**KIRKLEES METROPOLITAN COUNCIL
INVESTMENT & REGENERATION SERVICE**

DELEGATED DECISION TO DETERMINE PLANNING APPLICATIONS

Reference No: 2020/62/94070/W

Description: Use of premises for self-service launderette facility
and associated works

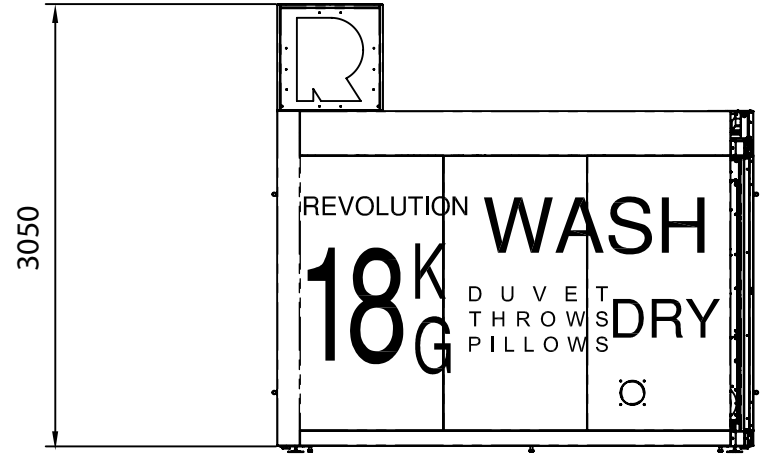
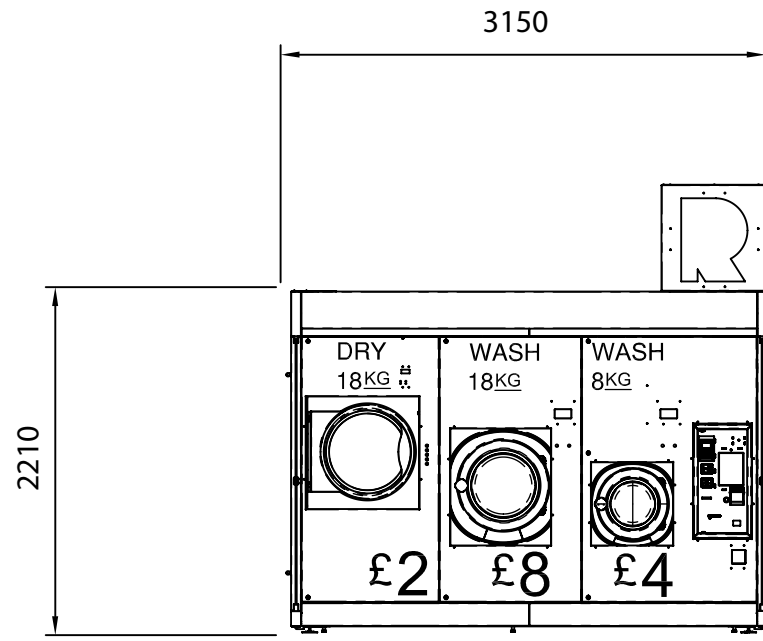
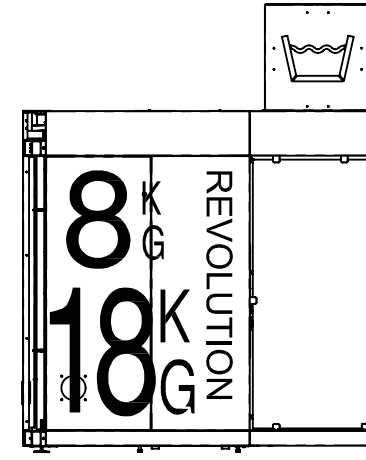
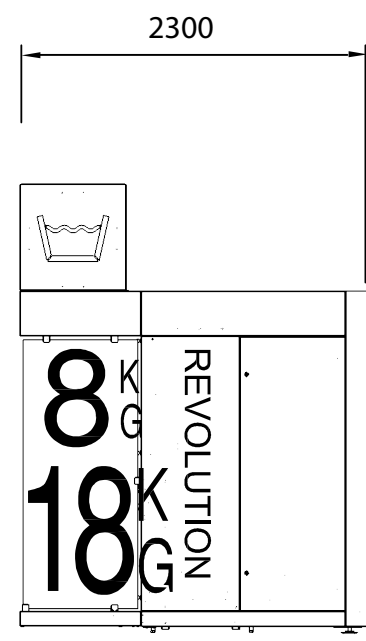
The self-service laundrette facility is located to the front of the ‘Premier Express’ convenience store, upon a large span of courtyard space present to the front elevation of the application site. Due to the size and scale of the facility and its siting, it is overtly prominent within the streetscene. Due to its prominent position visually, the self-service laundrette facility also results in a cramped, overdeveloped appearance to the front of the site; whereby, a relatively large extent of the currently open space is built upon. In addition, the facility has solid elevations in the colour grey, with additional graphics and manifestations, making its overall appearance incongruous with the established characteristics of the streetscene. Furthermore, the washing machine doors and payment system on the front elevation contribute further

to increasing the visibility of the facility, negatively increasing the industrial appearance of the development and in turn, further counteracting with the traditional appearance of the application site and streetscene. Finally, to overcome the topography of the land, the facility is elevated using a crude wooden levelling system, this increases the extent of detriment caused visually, amplifying the obtrusive nature of the overall design.

Jubilee Lane is immediately east of the site and serves many dwellings as a rear access. In order to provide a safe access onto Cowlersley Lane visibility splays at the junction of Jubilee Lane onto Cowlersley Lane should be 2.4m x 43m as it is a 30mph road. The self-service laundrette unit would significantly obscure the visibility at this junction to 2.4m x 18m. This would result in an unacceptable impact on highway safety, contrary to para 109 of the NPPF.

2. The siting of the self-service laundrette would significantly obscure visibility left (west) for vehicles emerging from the junction of Jubilee Lane with Cowlersley Lane. This would result in an unacceptable impact on highway safety contrary to Policy LP21 of the Kirklees Local Plan and paragraph 109 of the National Planning Policy Framework.
